Our Ref: 23/02853/FUL
Your Ref: unit 15-16 Road Farm

**South Cambridgeshire District Council
Application for Planning Permission**

Proposal: Change of use to retail.

Site address: Road Farm Ermine Street Shingay Cum Wendy Cambridgeshire

Ground Floor

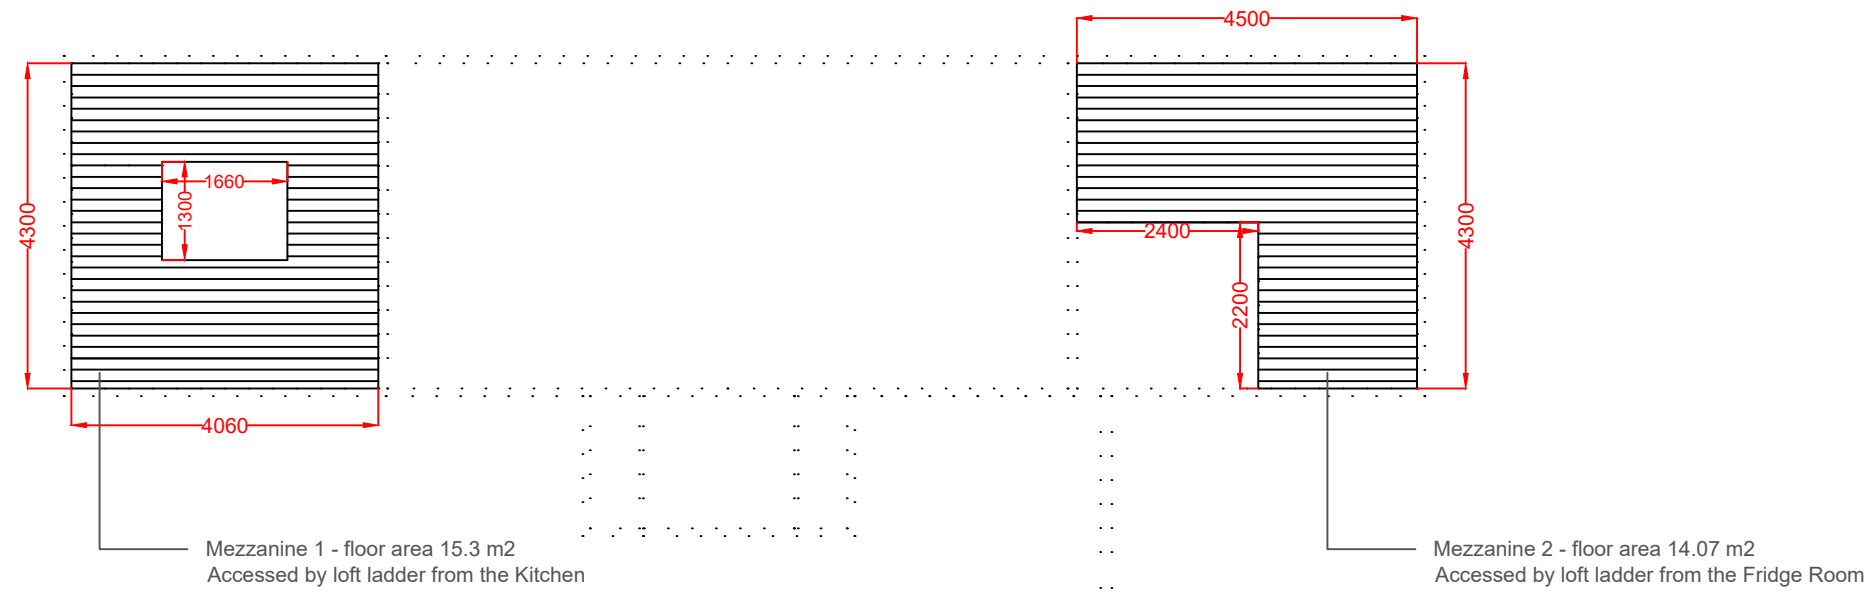
2. Please provide existing elevations. Please ensure these are at a scale of 1:50/1:100, show all sides including blank elevations.
3. Please clarify whether the floor plans are existing or proposed.
